**Consultation Response from KC,
Highways Development Management**

2022/90206 Carter Plantation Farm, Thick Hollins Road, Meltham, Holmfirth, HD9 3XD

Erection of agricultural workers dwelling

Date Responded: 21/02/22

title **Site Plan & Location Plan - As Proposed**
number **21086D-03-P03**
scale **1:500 & 1:1250**
size **A1**

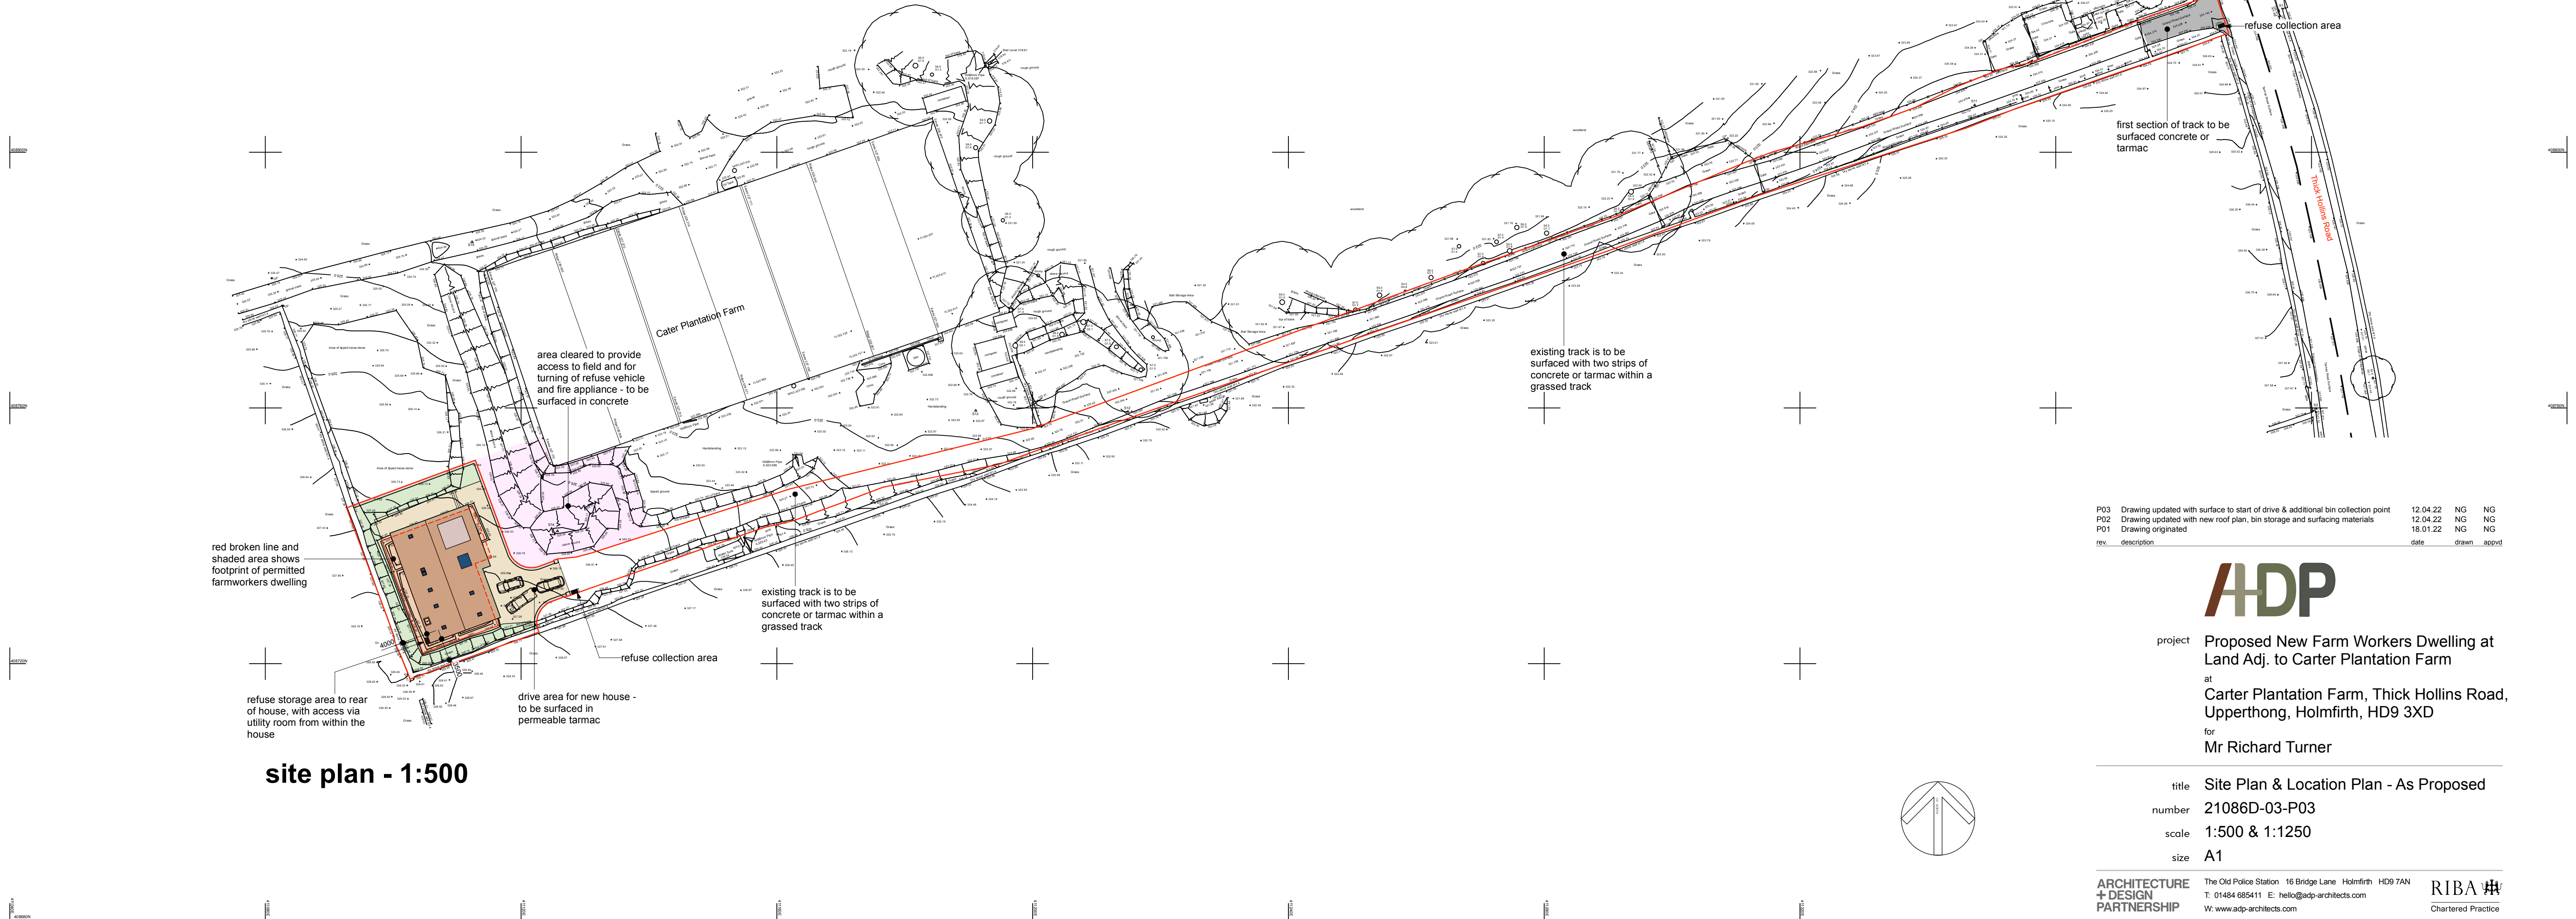
Although the scheme does not raise any insurmountable issues in term so of highways, officers would ask for the following information to be able to make a full assessment:

- Bin storage and collection pads demonstrated on a plan.
- Surfacing details of the area to be used for emergency vehicle turning.
